Your Ref: OWPC3997
Our Ref: WA/48/14/PL 21-08-2014
Please ask for:
Mr D Sullivan

Demolition of existing commercial buildings/garages and erection of 3 No 2 bed terraced dwellings along with provision of ancillary parking, turning and landscaping (re-submission of application WA/52/13).

Deans Yard Orchard Way Fontwell

Proposed Site Layout

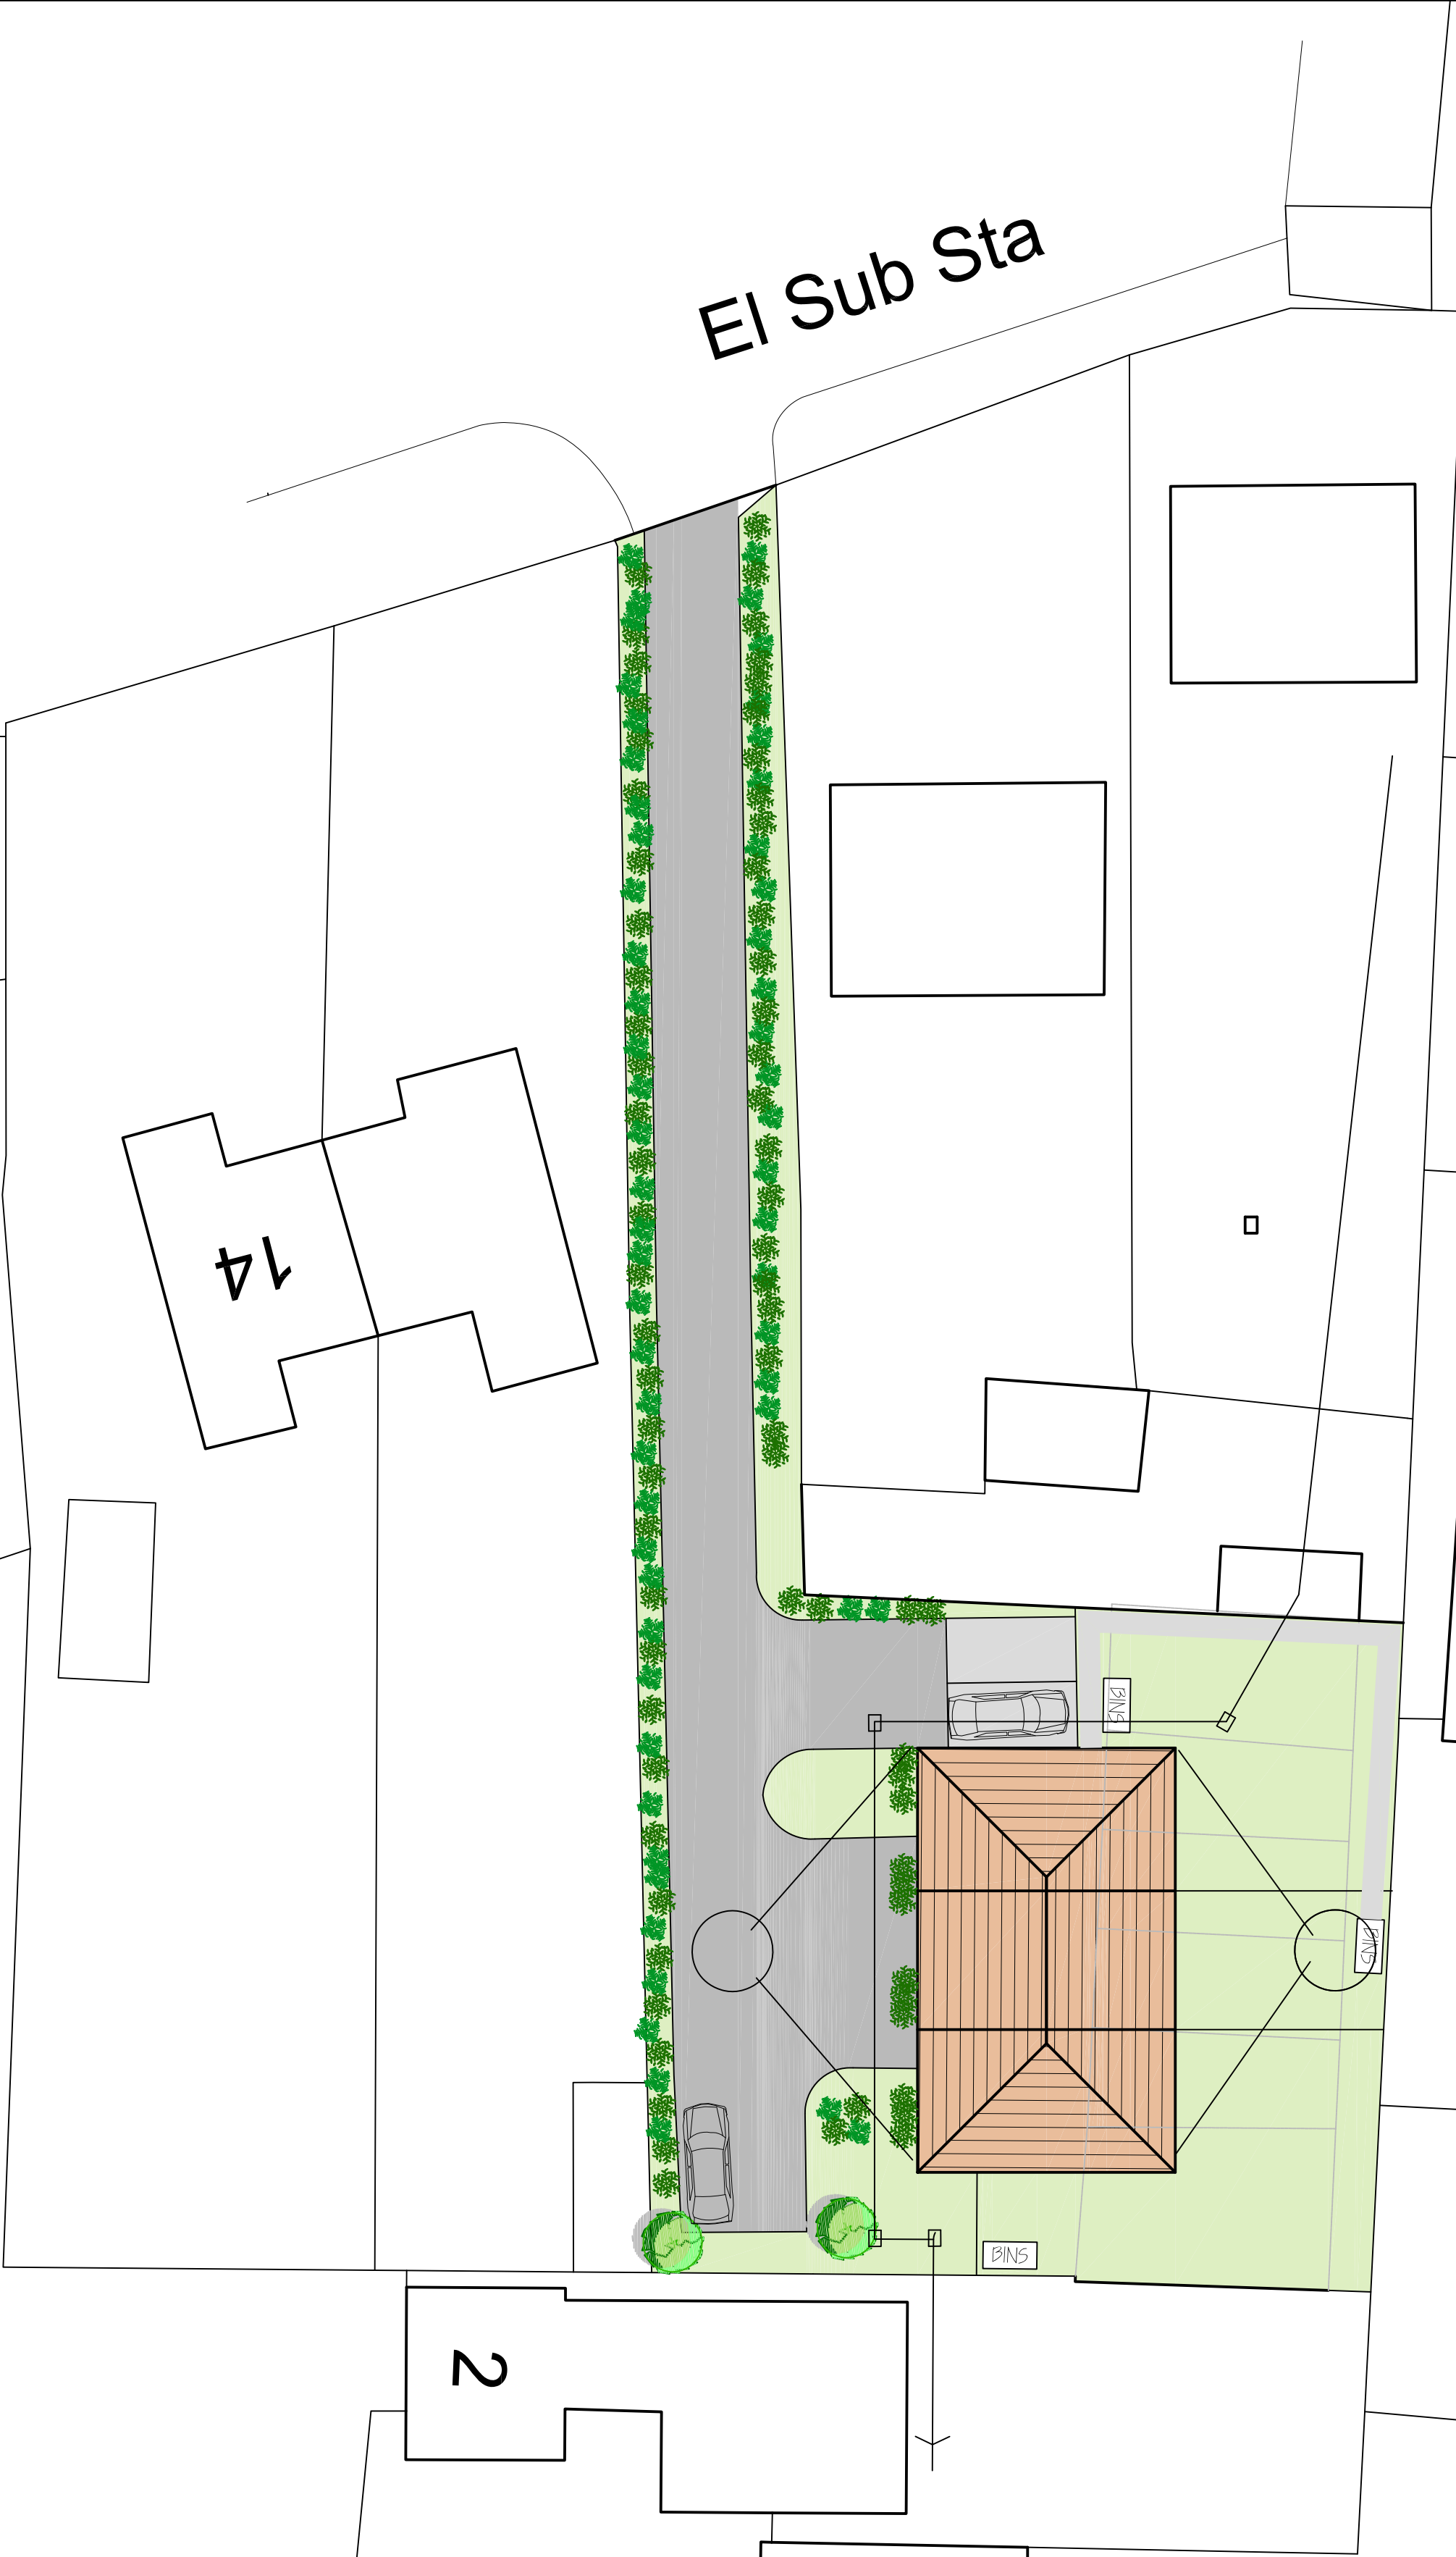
- moving the building a little further from No. 2 Deans Close (so presumably closer to the rear of Orchard Way properties)*
- making one of the upstairs rooms a study instead of a bedroom*

- suggesting the properties will be 4-person dwellings instead of 5-person; but my objections to the potential cramped development, with insufficient parking, vehicle turning and outside space remains the same. The D&A statement says there will be parking for 4 cars on the site. Most households now have at least 2 cars each; where would any additional vehicles and visitors park? Orchard Way is a narrow road with little space for parking without obstructing traffic, existing driveways, pavements and pedestrians. The D&A statement asserts that No.2 Deans Close would be most affected (I suggest that 18 & 20 Orchard Way would also be significantly affected)with adverse impact on several other houses in Hunters Mews, Orchard Way and Deans Close too. The D&A statement says there was no objection from the residents of No. 2 Deans Close. No. 2 is on the market for sale at present which could explain why the owners were either reluctant or disinterested to object to the application. There is no similar (cramped, terraced) development nearby. The new application shows 3 x 2-bedroom terraced properties with a home office as the third upstairs room and the D&A statement suggests that these would be 4-person dwellings. Bedroom 2 appears very small for 2 people. Other key reasons for my objection:*

- Lack of space for people, parking, wheelie bins, visitors and deliveries.*
- Much-increased traffic to/from the site if it is used for 3 residential dwellings compared with currently, and for 7 days per week rather than the current 5 days.*

- Narrow, single-track access to the site could create turning / access / pedestrian problems.*
- In 2010 permission was granted for 1 bungalow on the site(which would have its own access driveway, not one shared with 2 other dwellings and which would not overlook (nor over-crowd) existing neighbouring properties). This would seem a much more pragmatic, sympathetic use of the space than the current proposal to cram in as much as possible . Please consider the likely quality of life for residents of such a development and for those who live in the close-surrounding area. Thank you.*
